Our ref: WA/2021/129266/05-L01
Your ref: 21/02286/F
Date: 09 January 2023

Construction of a coffee unit with drive-thru facility and indoor seating with associated access, car parking, landscaping and servicing parking

Land north west of Launton Road roundabout adjoining Skimmingdish Lane, Caversfield

Environment Agency position

DRAINAGE LAYOUT

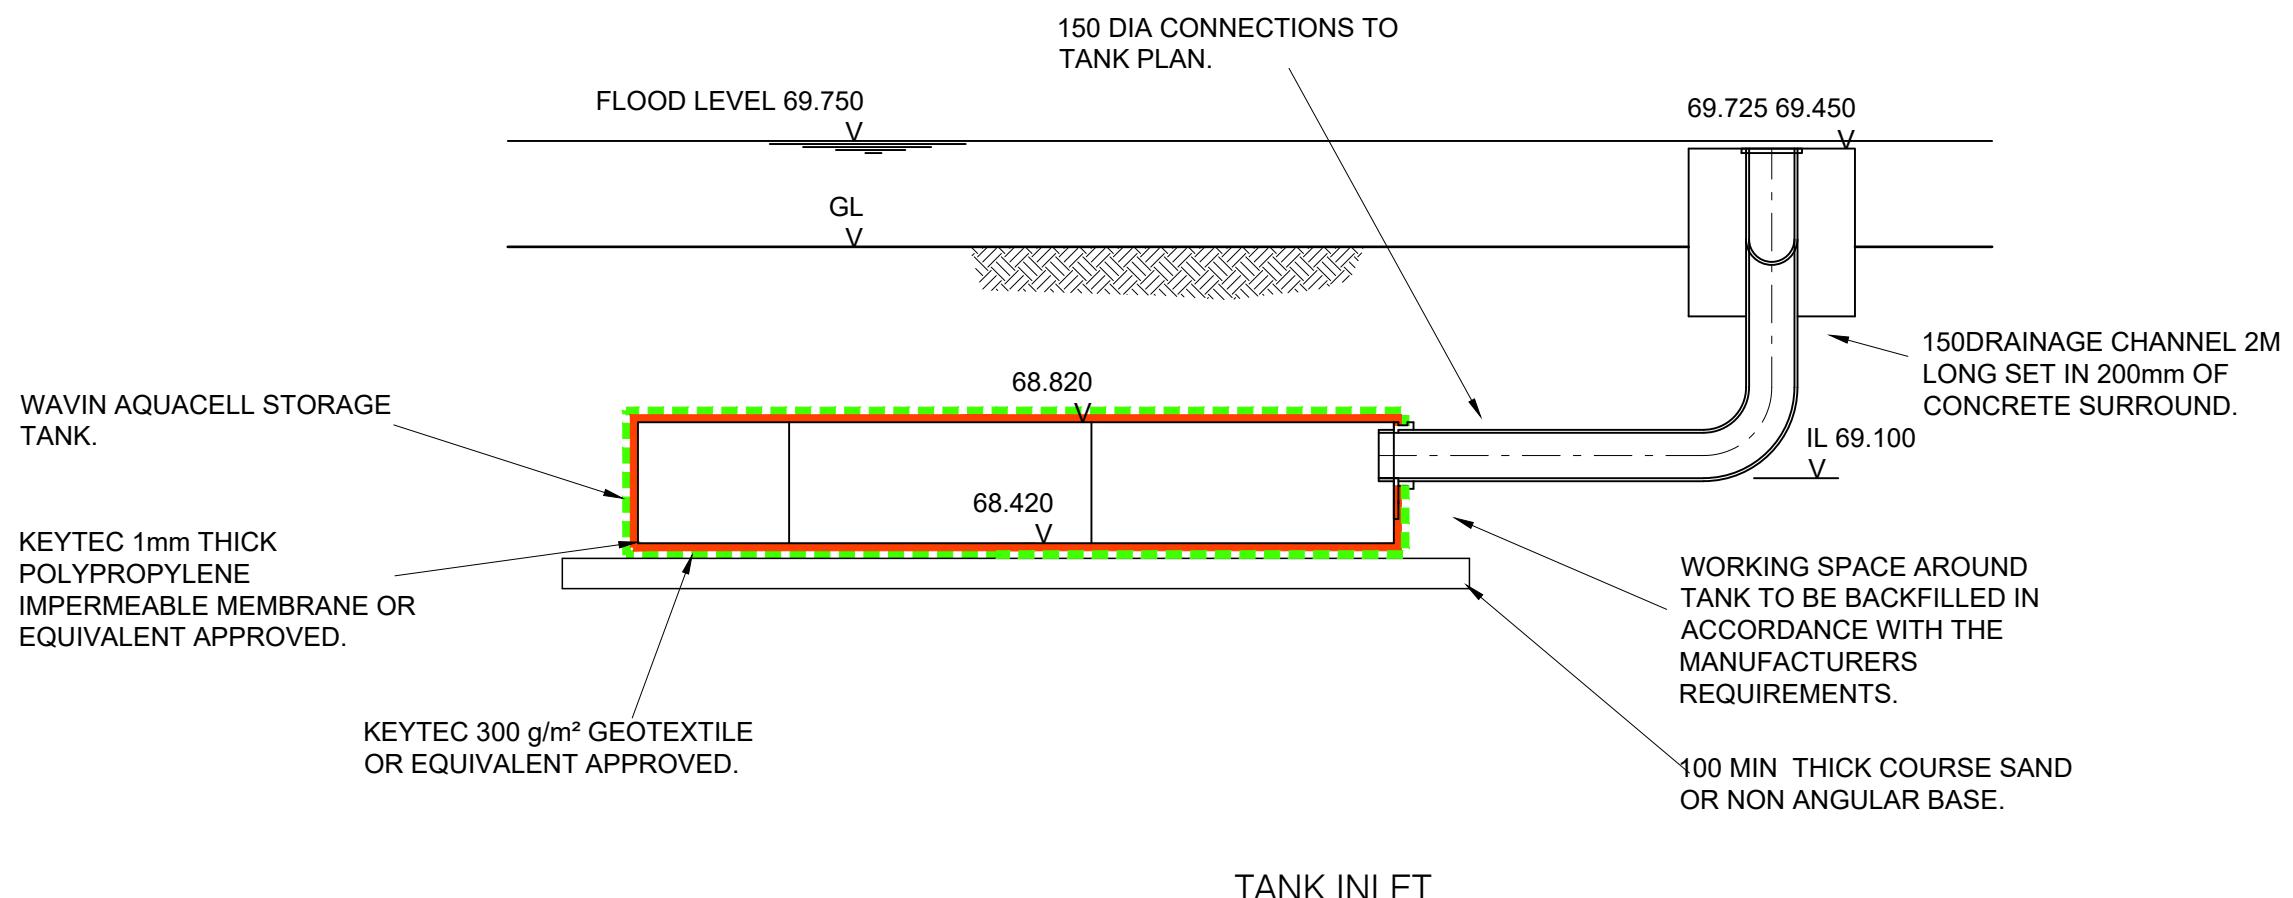
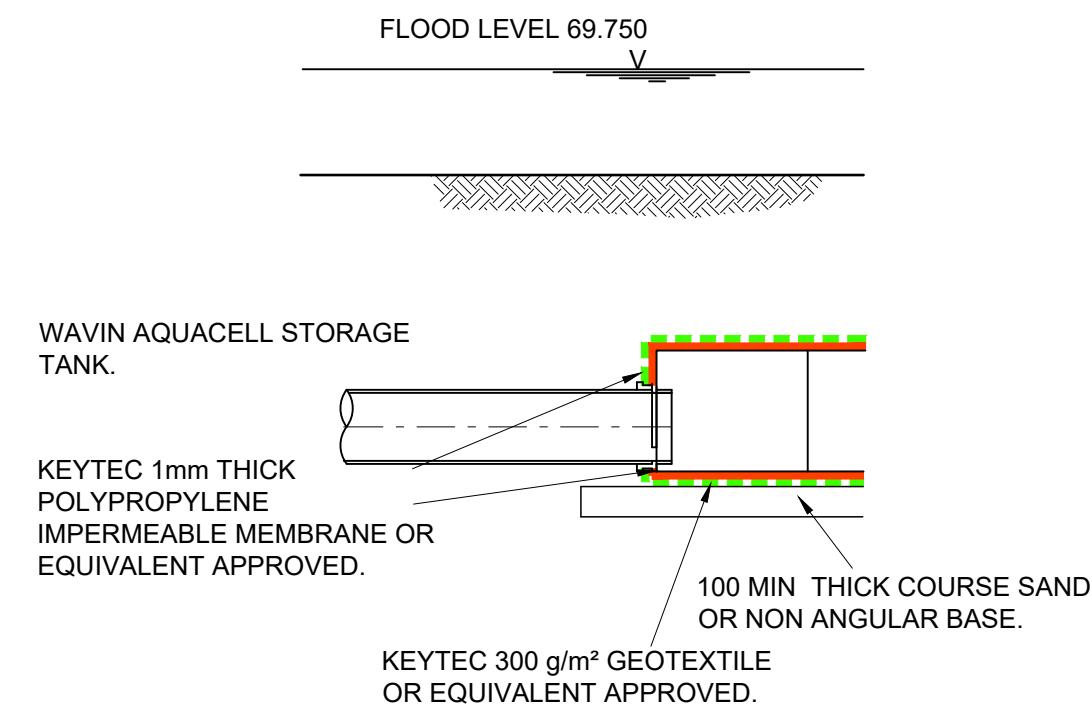
Further, the tank openings appear to be set at the wrong level for the flood band they are intended to be mitigating for. The applicant should explain why the tank openings are not provided at the bottom or middle of the relevant flood level band. These levels will also need to be revised in line with agreed flood levels for the site.
